# CITY OF ALBUQUERQUE

September 23, 2019

RE: **Drive Thru Restaurant**  
**700 Coors Blvd NW**  
**Grading Plan Stamp Date: 8/15/19**  
**Hydrology File: J11D039**

Drawing No. **GD1.0**

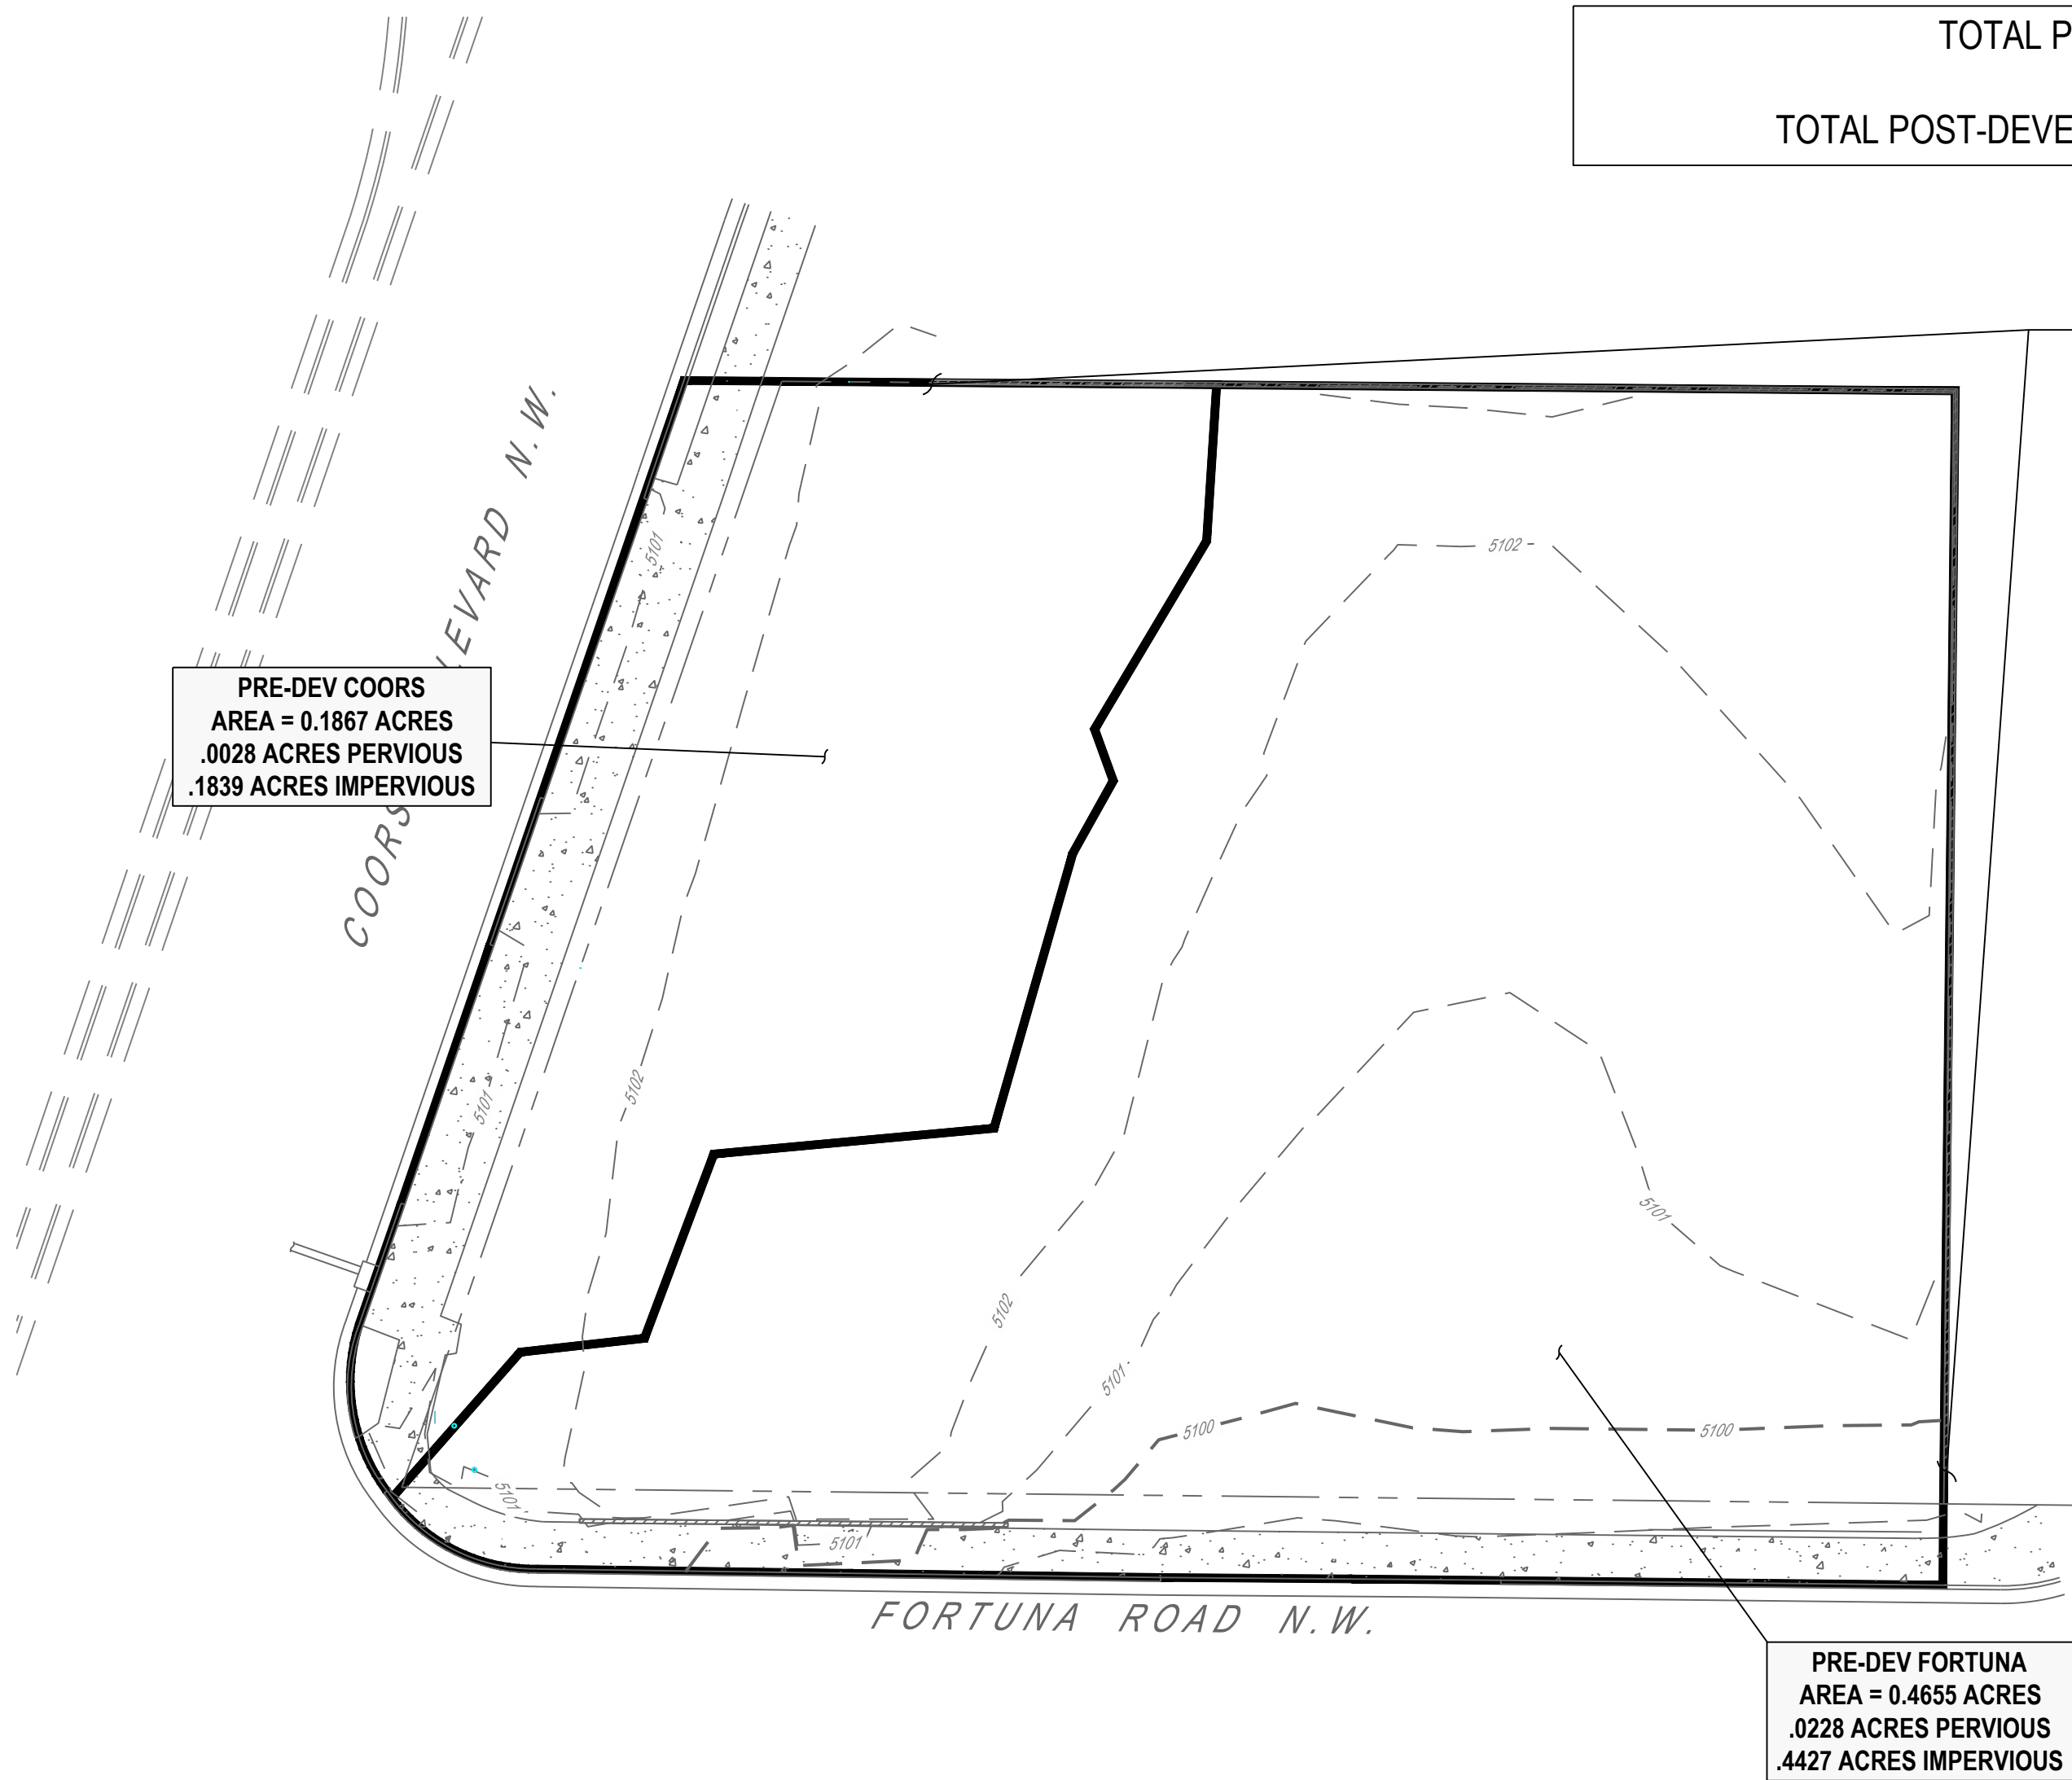
1. Runoff from impervious areas needs to be routed into the stormwater quality (SWQ) ponds. Please provide the SWQ volume calculations for each basin draining to each pond. The stormwater quality ponds need to be sized for the areas draining to them. It appears a large portion of the parking lot and roof simply flows out the driveway onto Fortuna.

6. For trash enclosures serving food service developments, demonstrate *control of liquids from dumpster areas* per DPM Chapter 22.9.E, Table 1 by: containing runoff from the dumpster area, preventing outside drainage from entering the dumpster area, and discharging to the sanitary sewer. If this information is on the utility plan please provide it, or show on the grading plan.
7. Show the work to close the extra driveway cut, reconstruct the remaining two driveways per ADA requirements, and any other work required in the ROW. Include spot elevations at flowline and highpoint, demonstrating a 0.87' (min.) waterblock.
8. Add a note on the Grading Plan, "Prior to any work within the New Mexico Department of Transportation (NMDOT) Right-of-Way, an NMDOT permit will be required." Provide a copy of the issued permit prior to requesting Certificate of Occupancy.

GD1.1

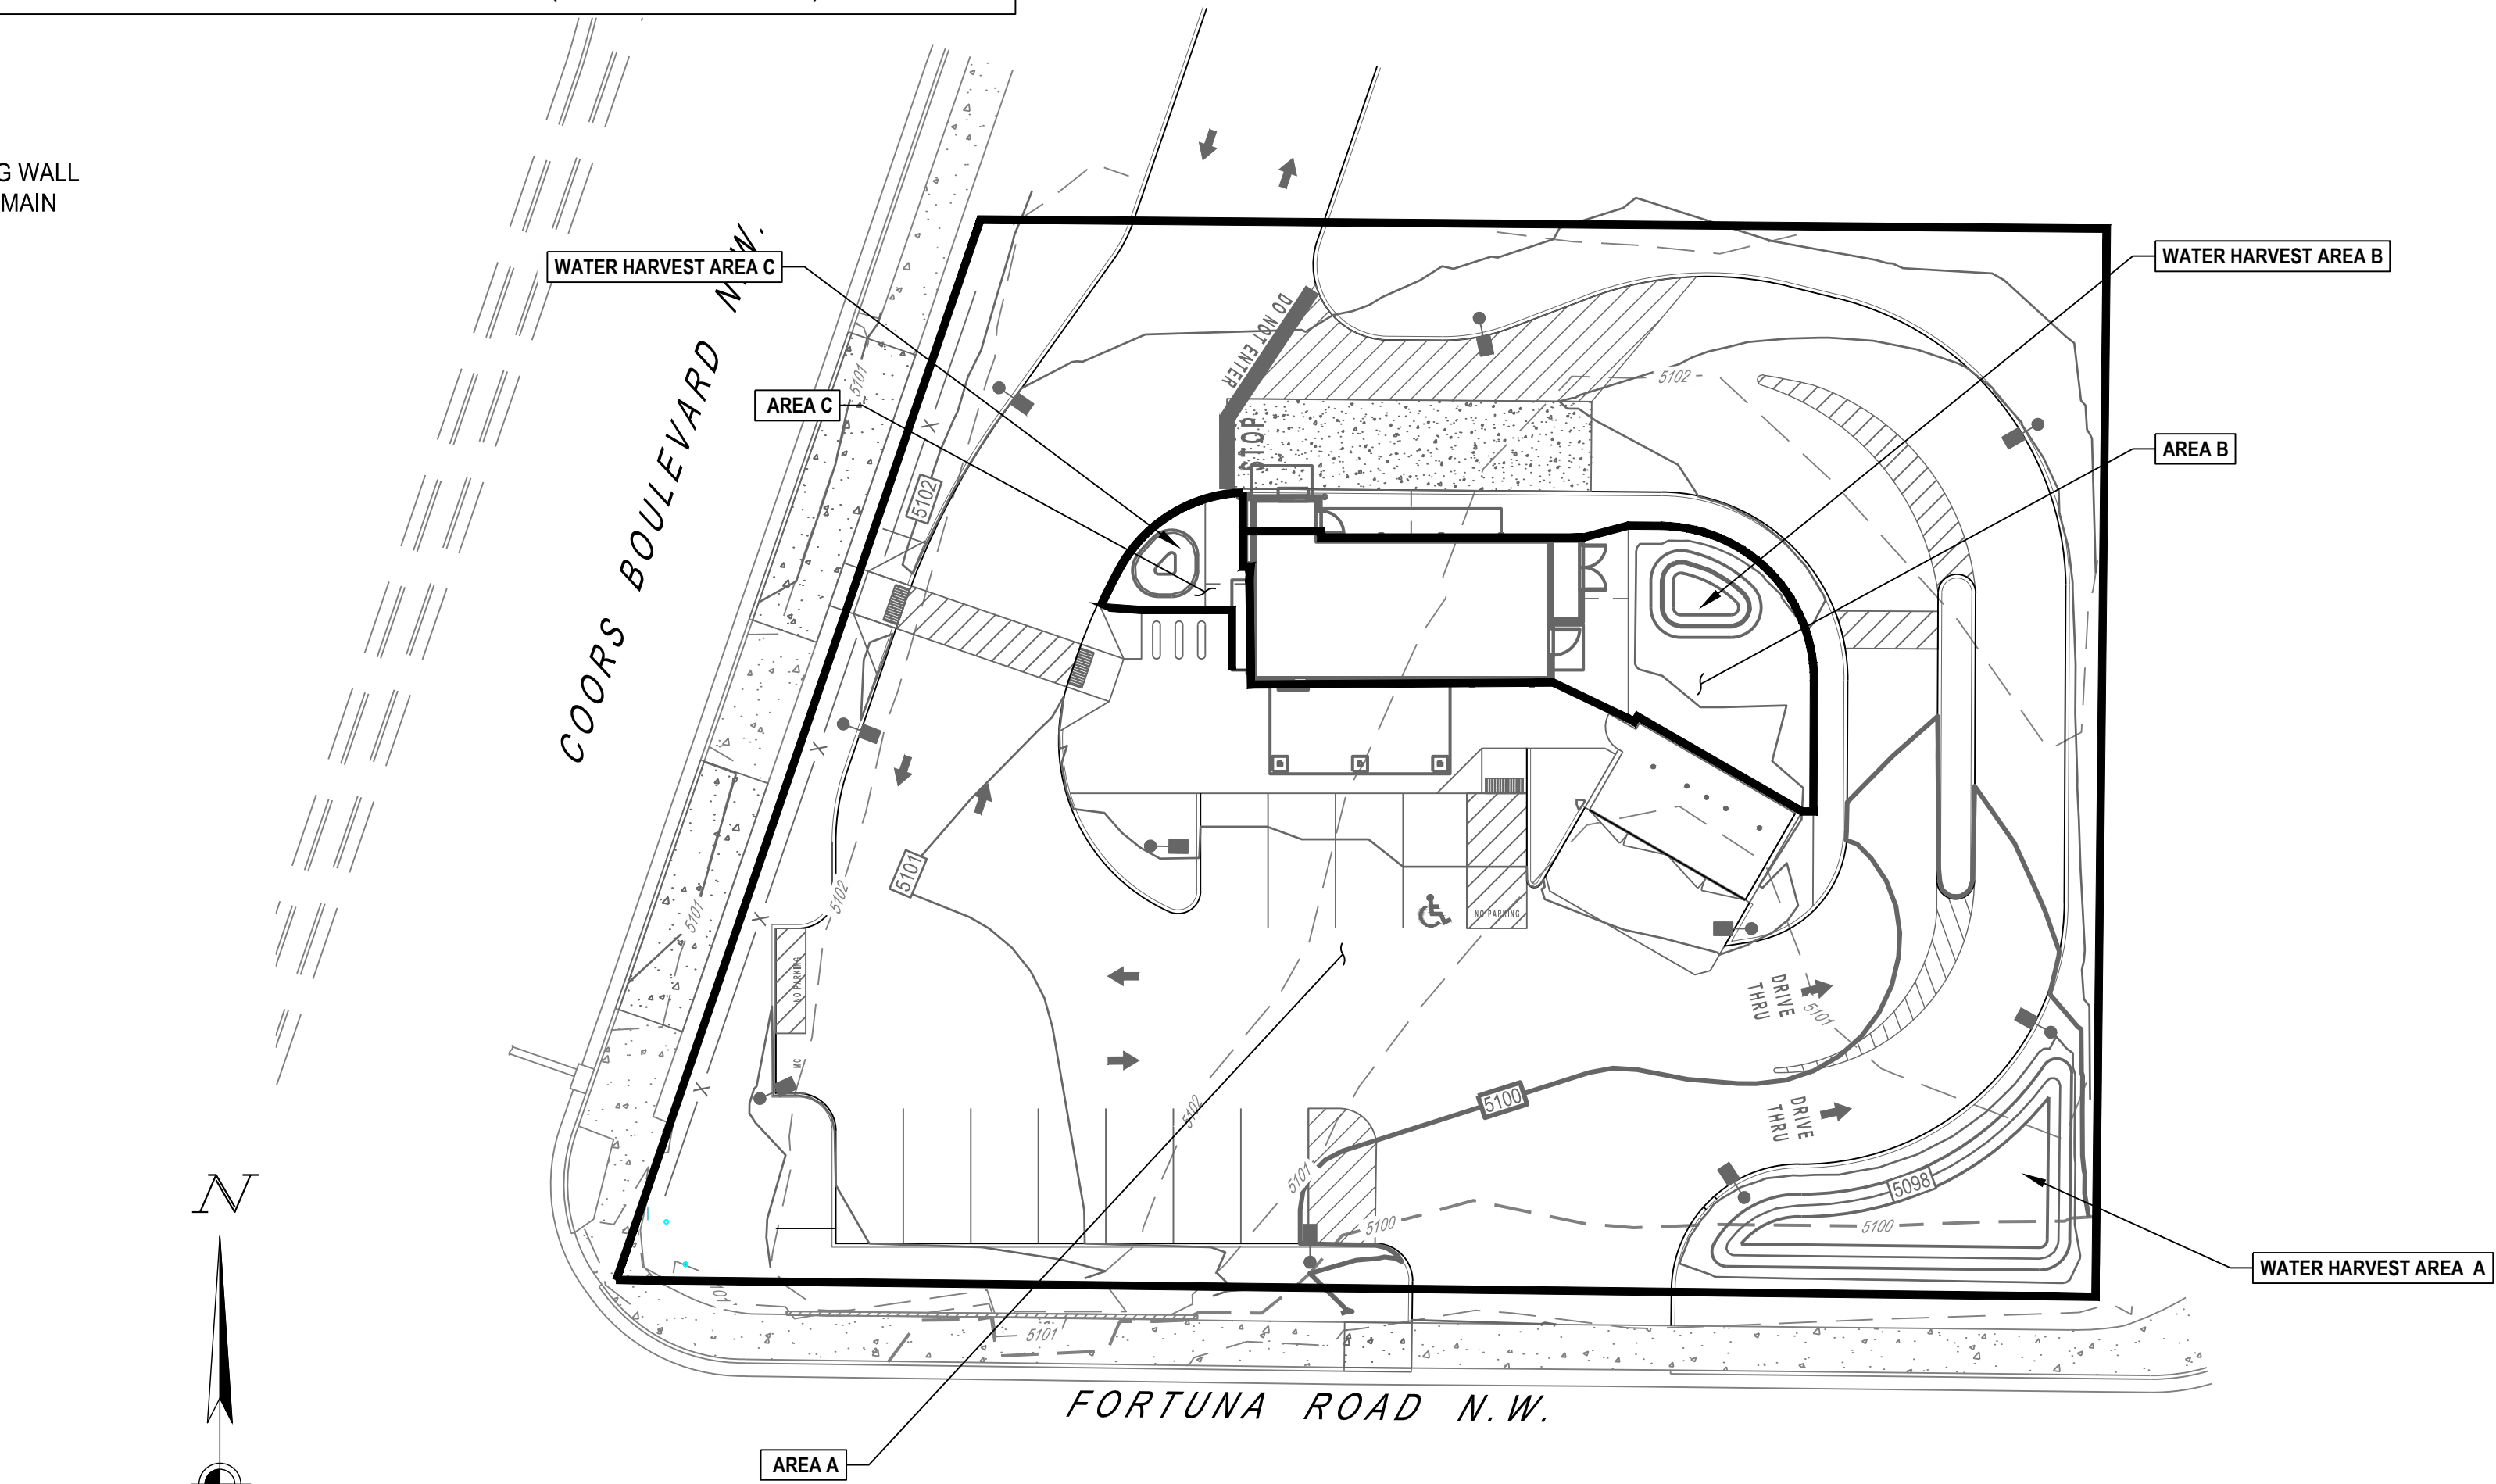
3. Provide hydrologic calculations per the DPM, Ch 22.2.A for the 100-yr storm. Also, a brief narrative describing the project and existing/proposed grading and drainage is recommended (DPM Ch 22.7: *Grading Plan Checklist*).

4. Provide outfalls for both ponds, sized for the 100-yr peak inflow. Include supporting hydraulic calculations as needed.
5. It appears that your engineering stamp is too big. The NM Board of Licensure for Professional Engineers and Professional Surveyors Administrative Code 16.39.3.12.C states, "The design of the seal/stamp shall consist of three (3) concentric circles, the outermost circle being one (1) and one-half (1/2) inches in diameter..."
